2 SECTION STAIR # 1
1/4" = 1'-0"

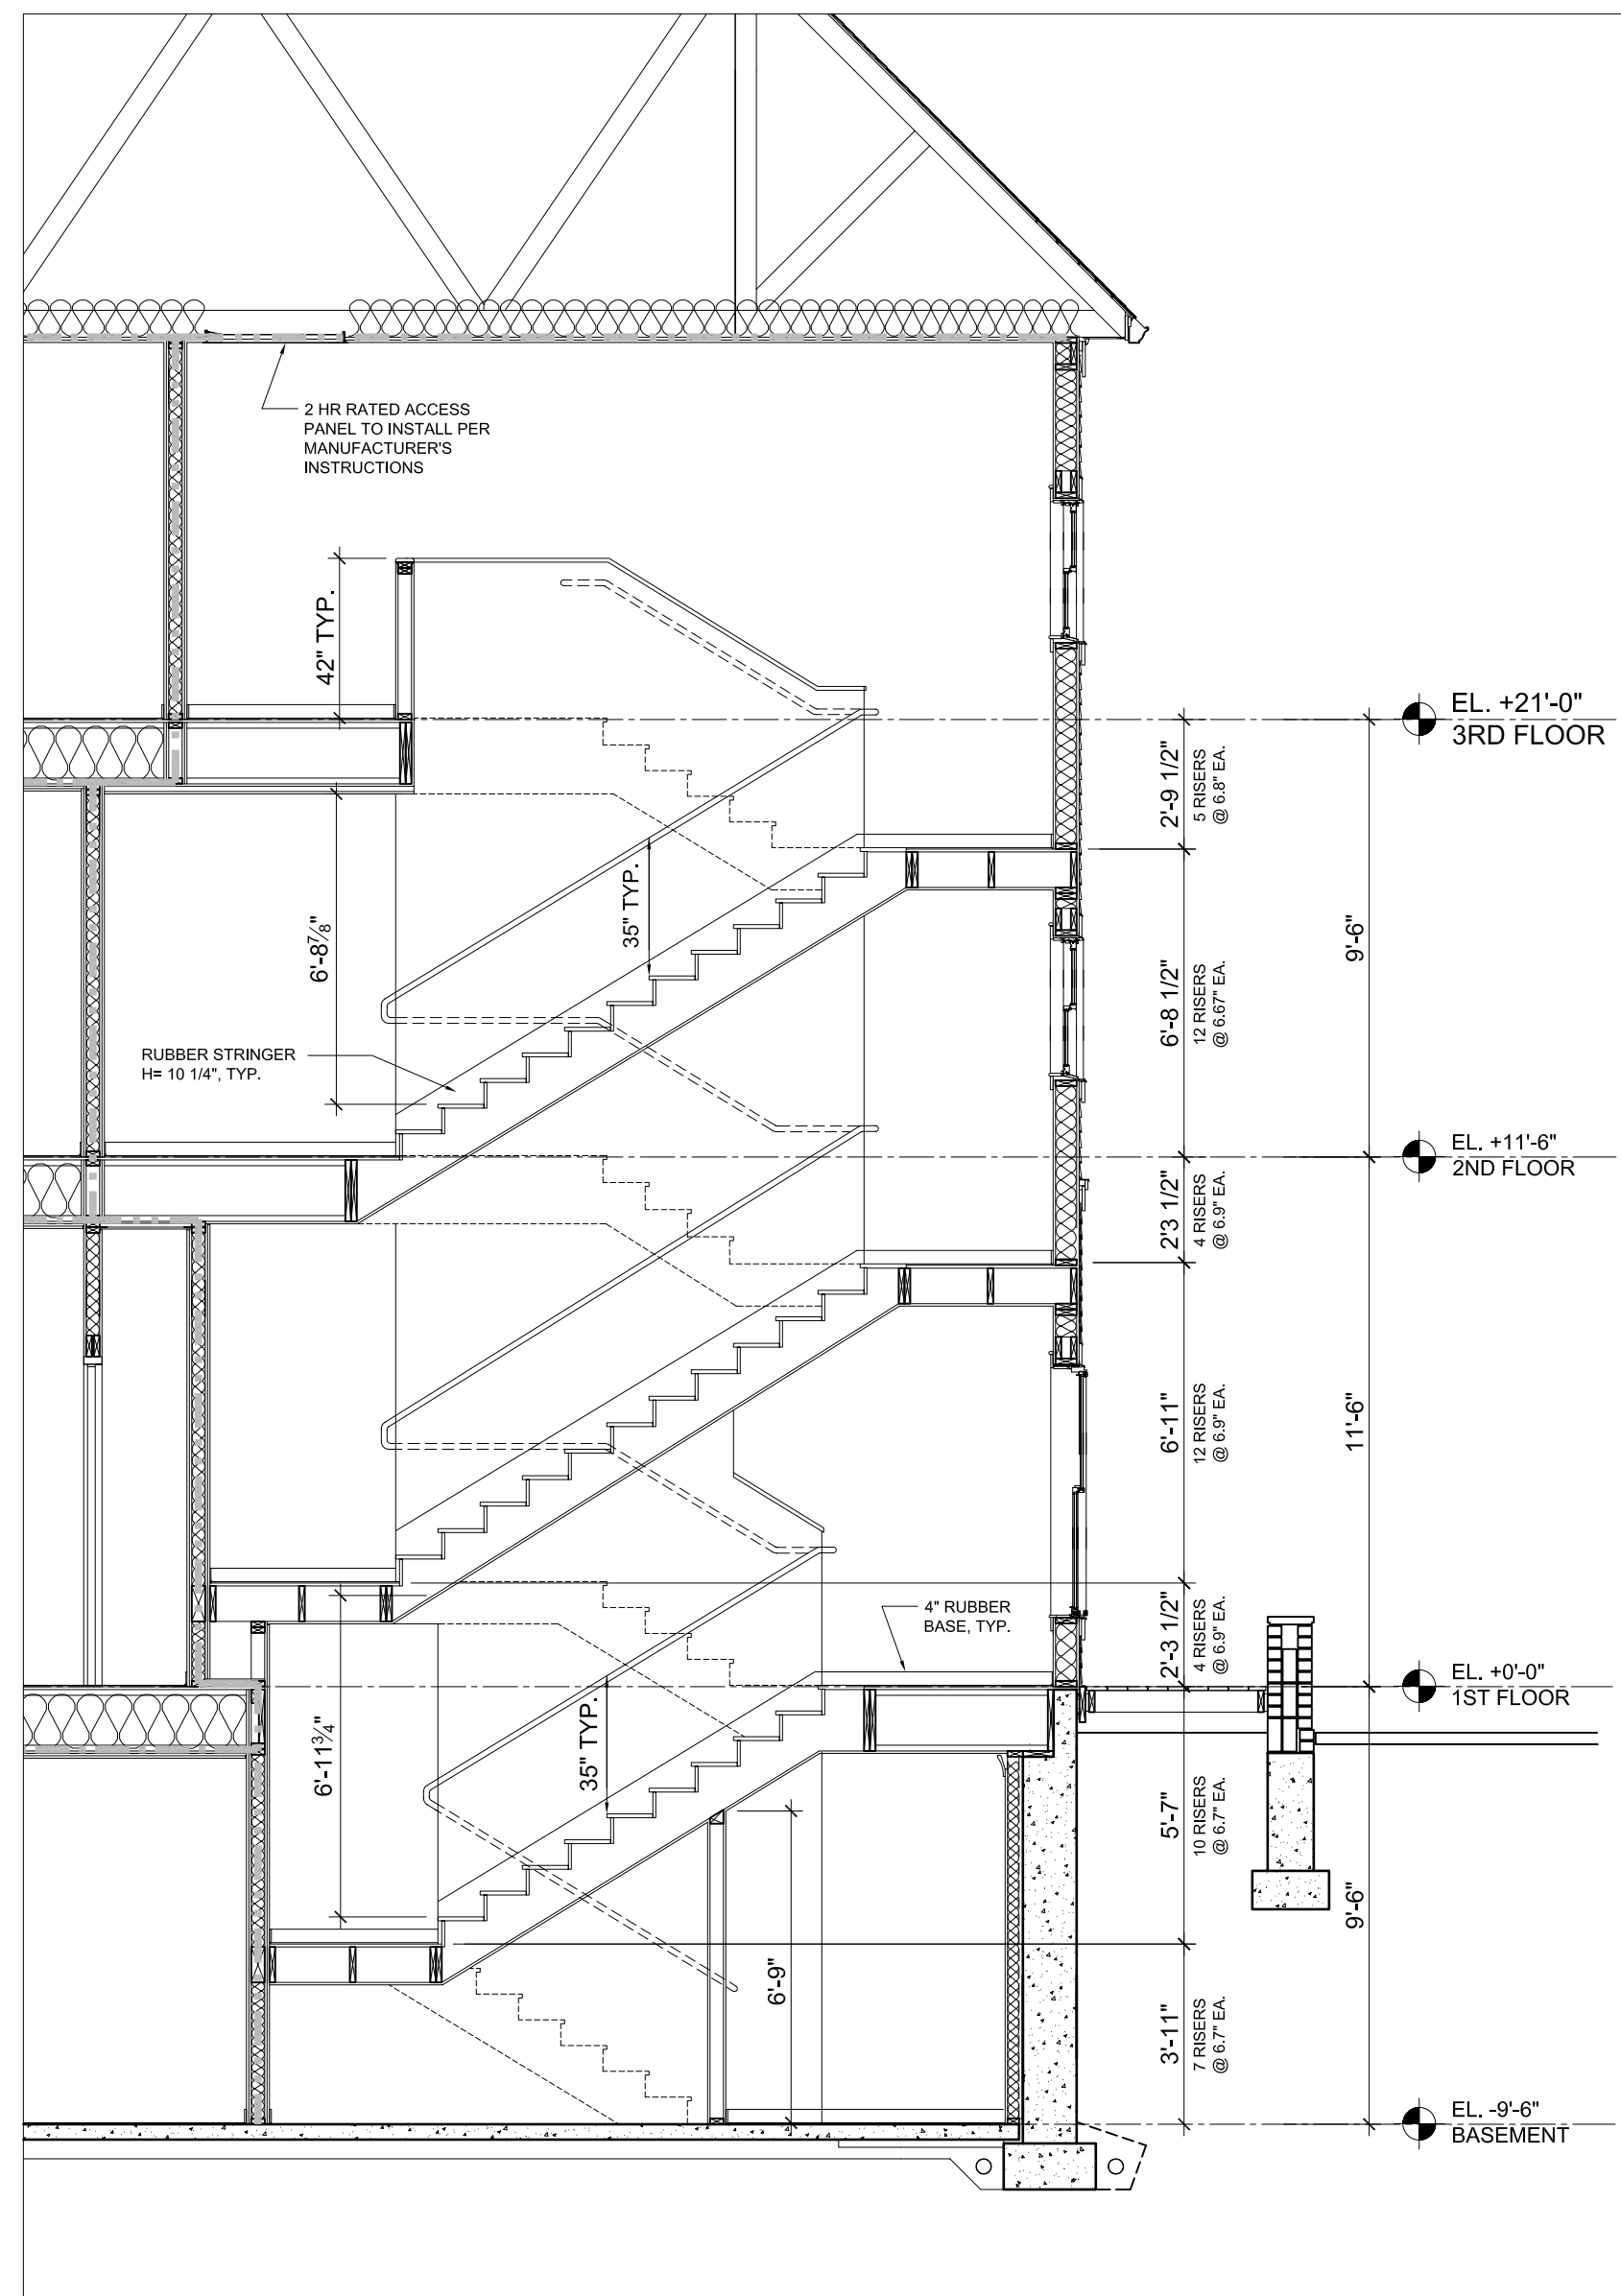
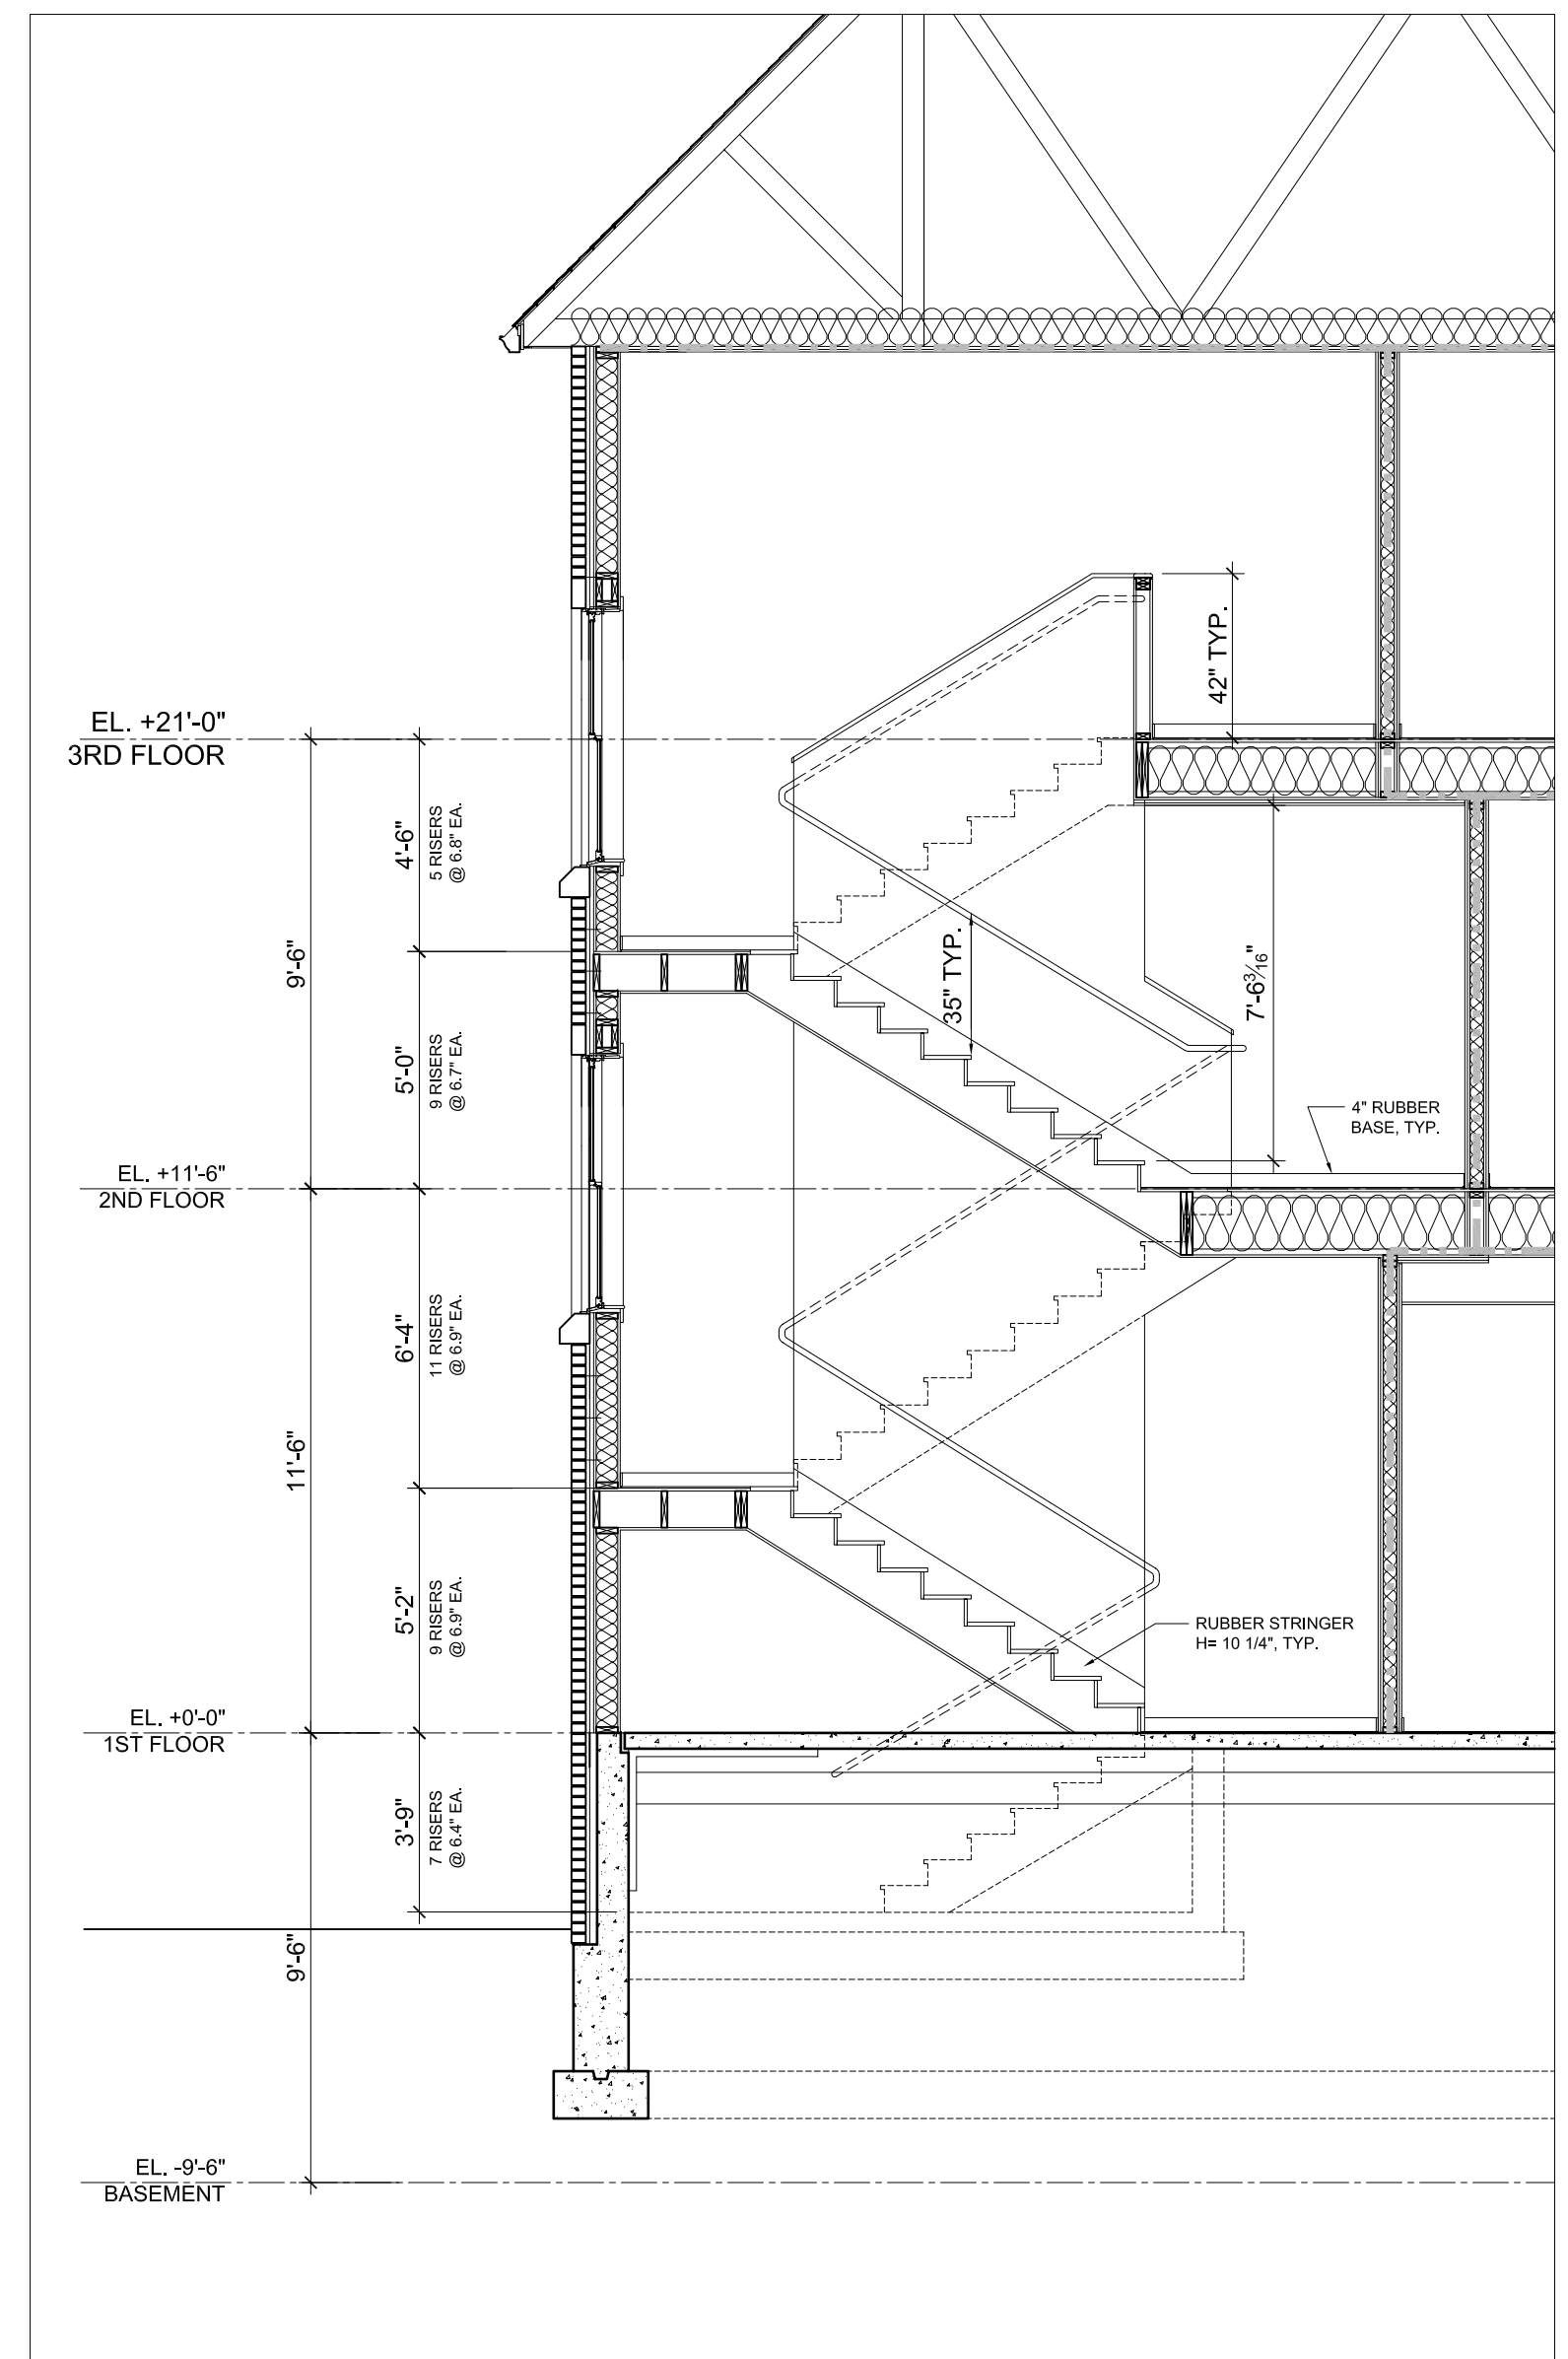
No.	DESCRIPTION	Code Section
1.	KITCHEN EXHAUST.	
2.	NOSINE DASTAIRS -	
3.	BARRIER DETAILED FOR GUARDS FOR RESTAURANT WARE - C-6	
4.	PORETT / BARRICADY GUARD DETAIL
